# MONA OFFSHORE WIND PROJECT

## Response to Section 51 advice

Document Reference: A6

April 2024

Temporary stopping up of public rights of way plan

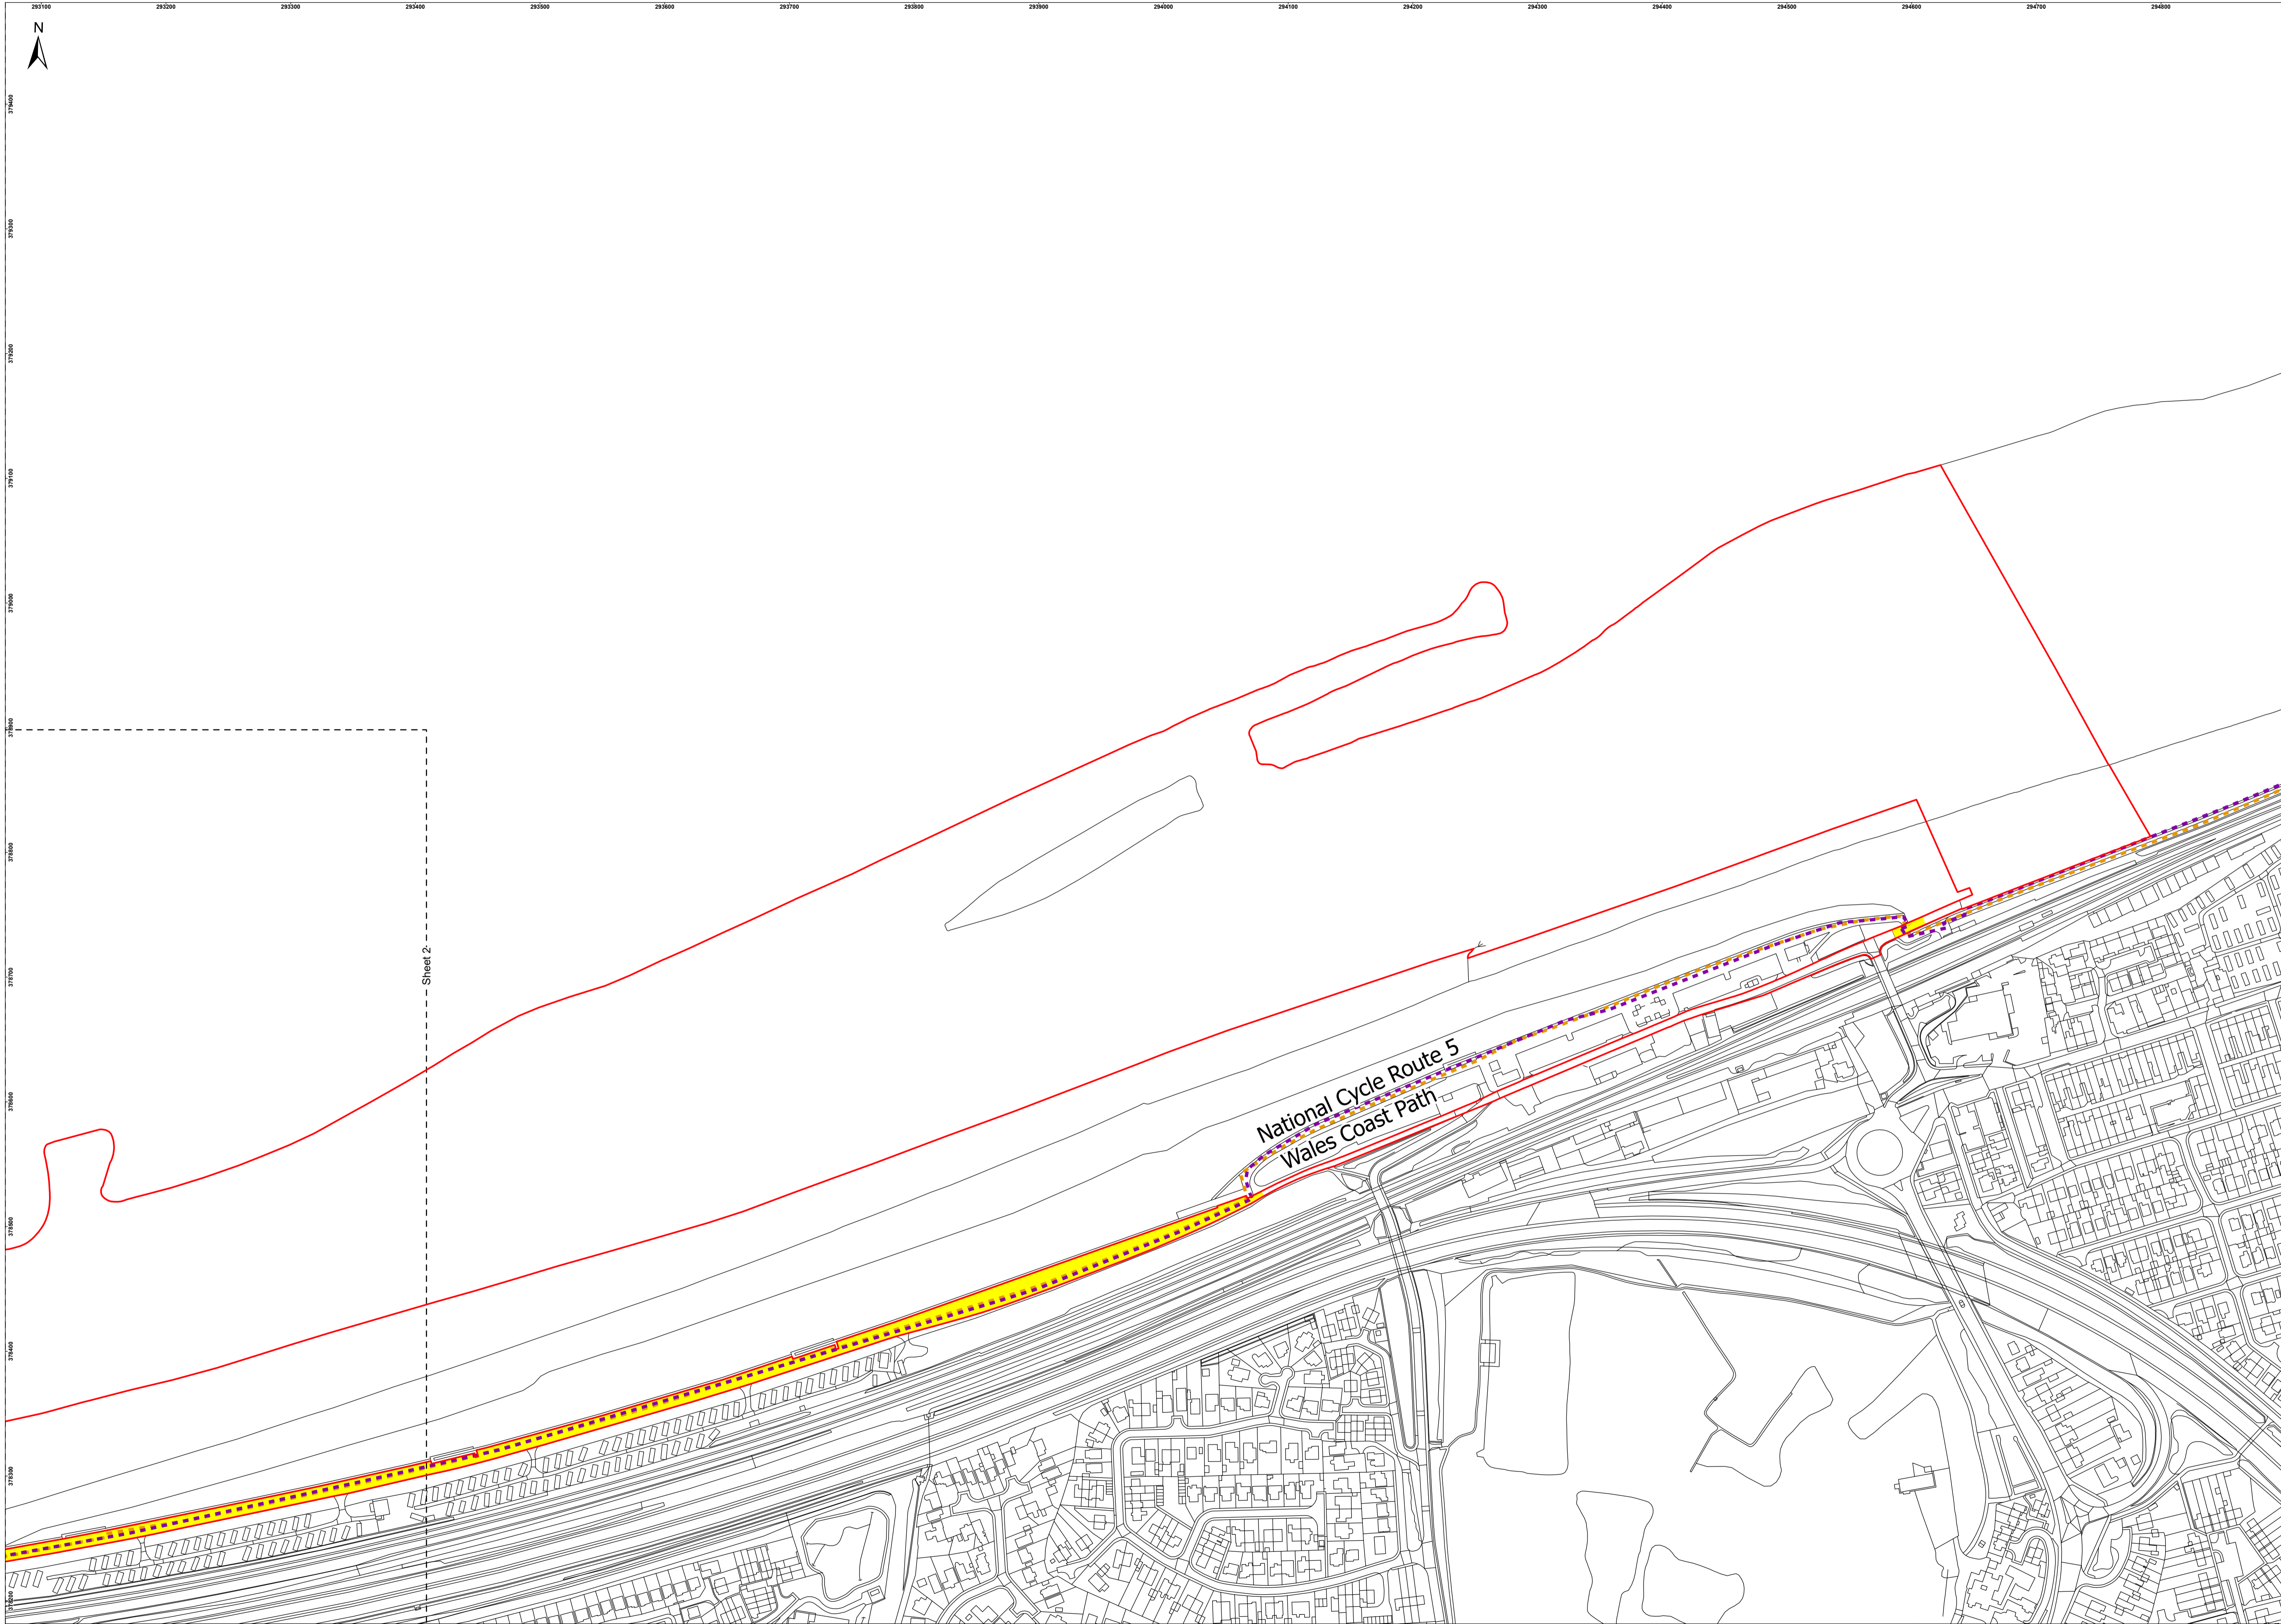
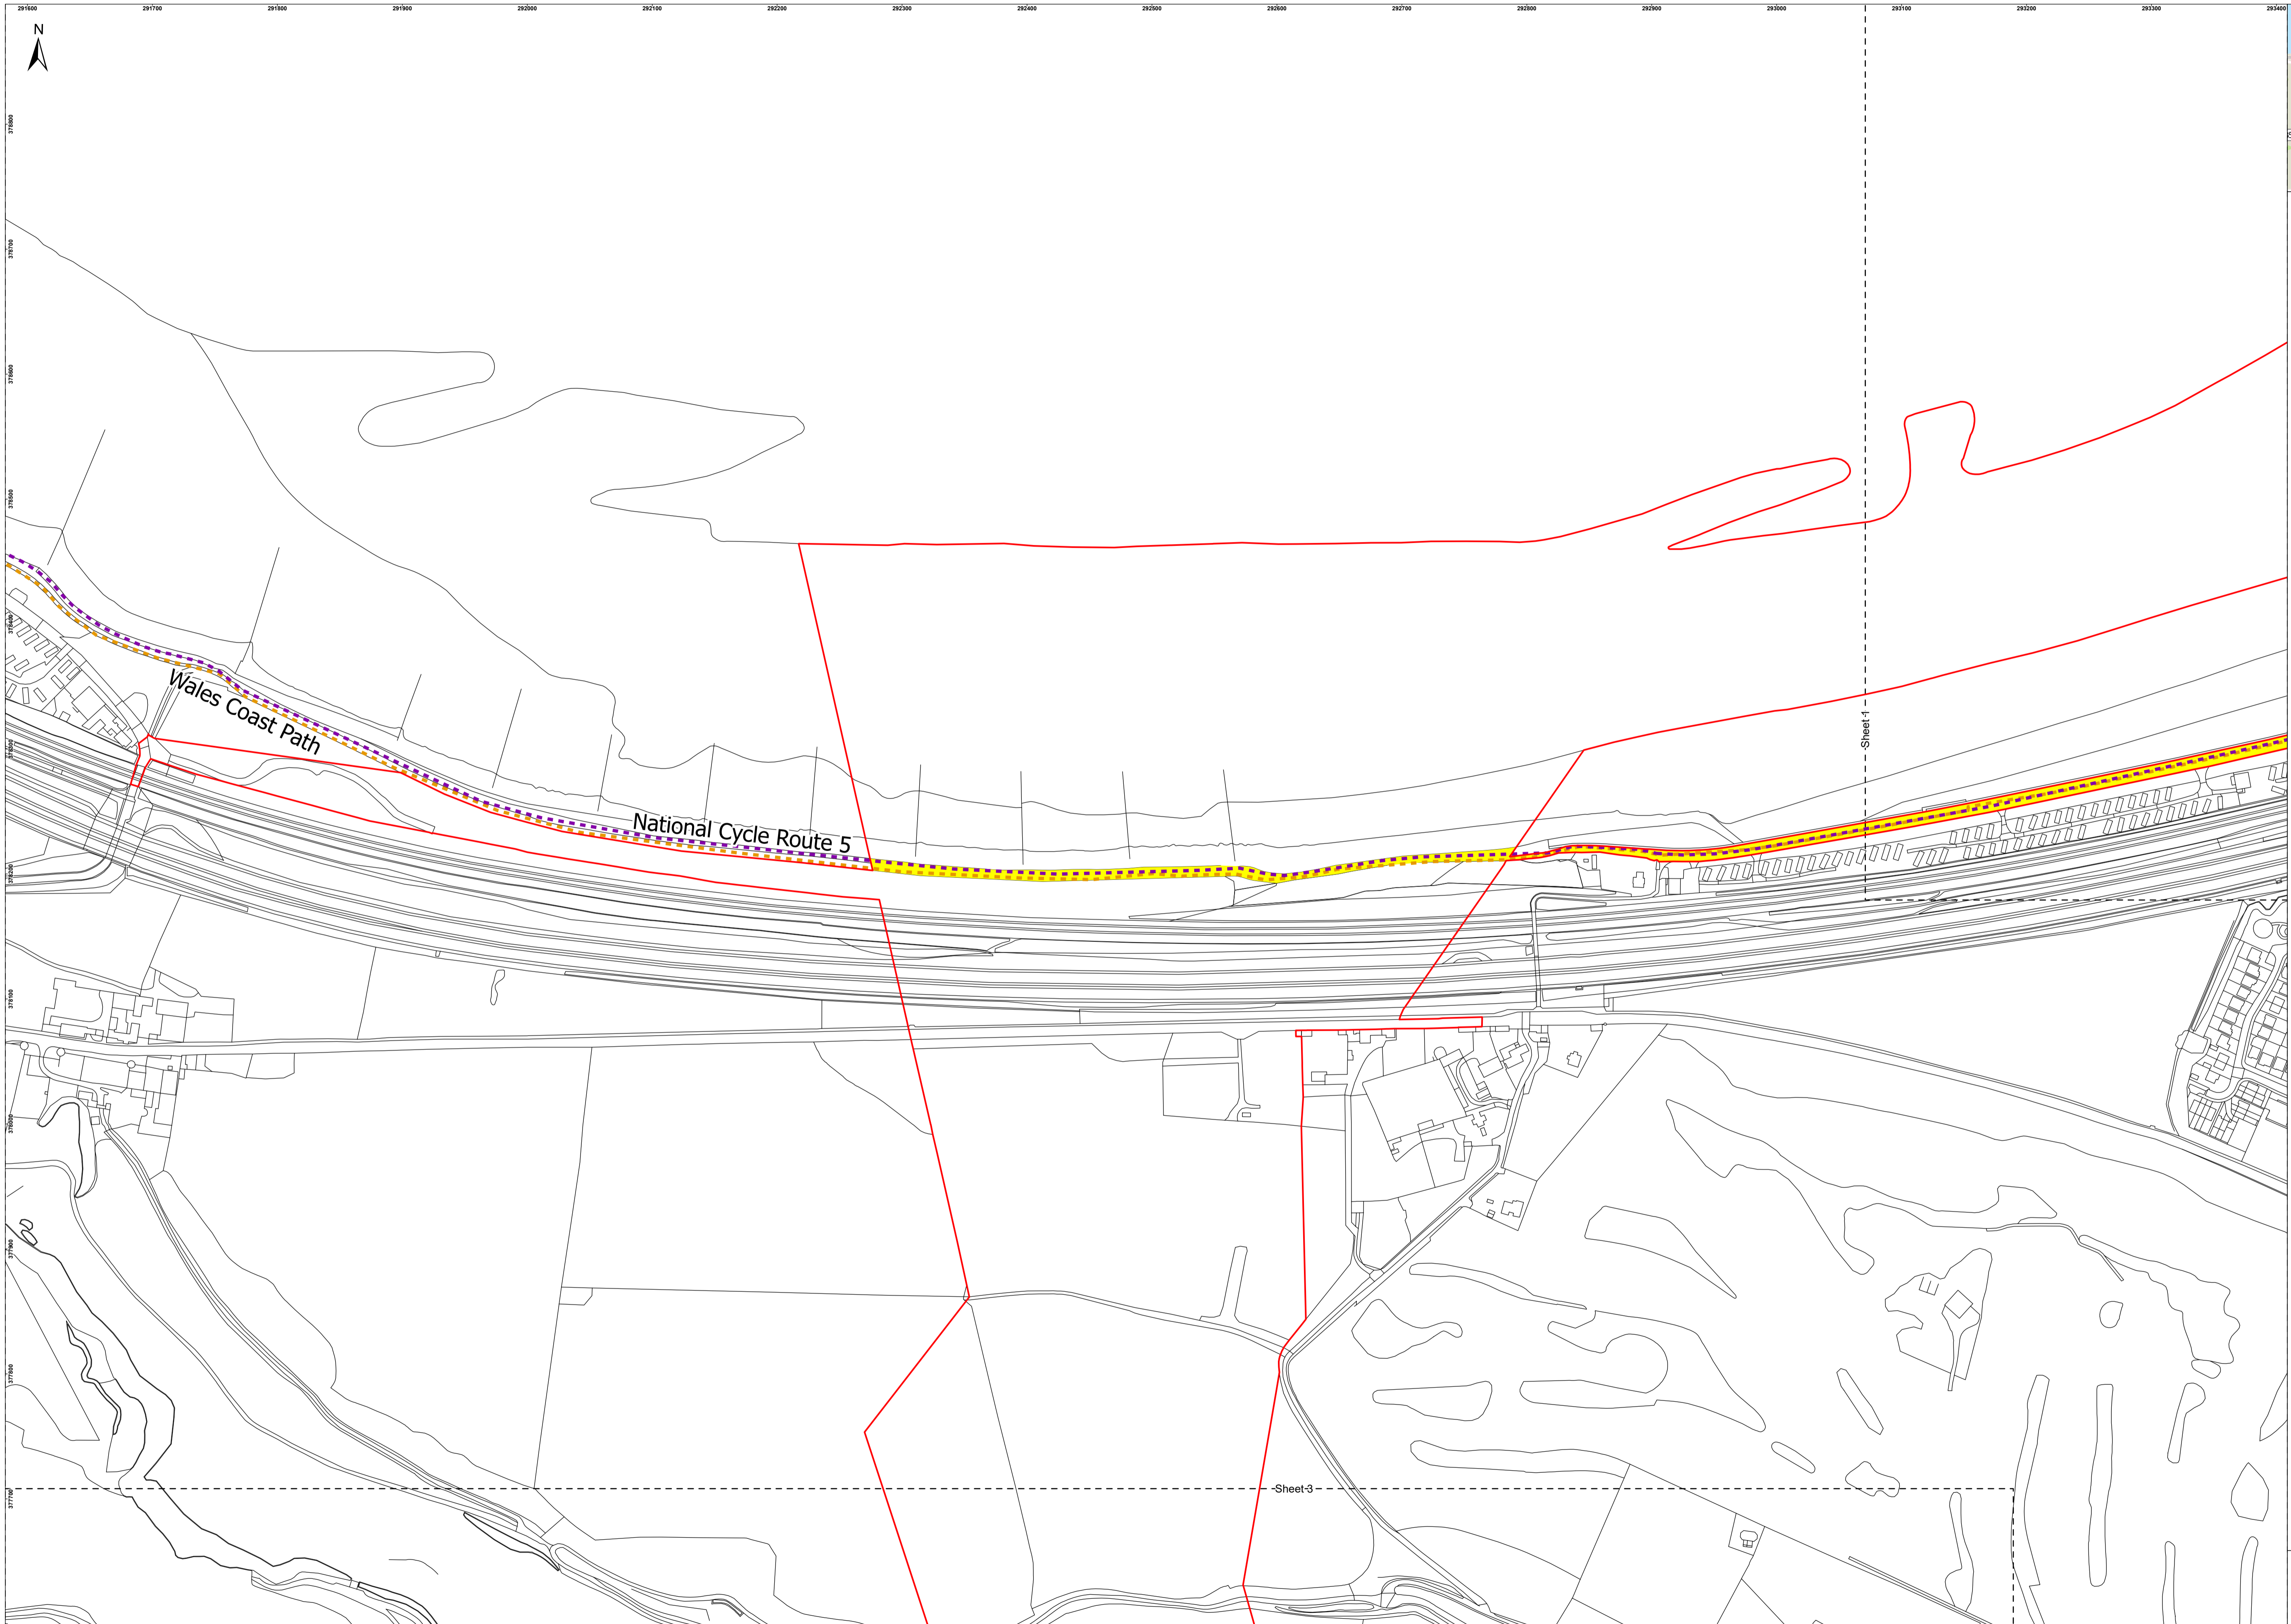
Topic	Section 51 advice	Applicants response
Observation in documents	Land Plan (Onshore) (Doc B5) Missing north facing arrow. Inset 5 (page 10) appears to use the wrong shade of green. For clarity, this should be corrected to use the same green as that in the legend.	This has been amended and the revised Land Plan (Onshore) (doc B5/F02) has been submitted to the Planning Inspectorate.
Observation in documents	Street Works and Access to Works Plan (Doc B15) Missing north facing arrow. The points on the plan (which are referred to in Schedule 3 and 4 of the DCO) could be slightly larger to aid comprehension. The points on the plan (which are referred to in Schedule 5 of the DCO) could be slightly larger to aid comprehension	These have been amended and the revised Street Works and Access to Works Plans (doc B15/F02) has been submitted to the Planning Inspectorate.
Observation in documents	Temporary Stopping up of Public Rights of Way Plan (Doc B16) Missing north facing arrow.	This amendment has been made and a revised Temporary Stopping up of Public Rights of Way Plan (doc B16/F02) has been submitted to the Planning Inspectorate.
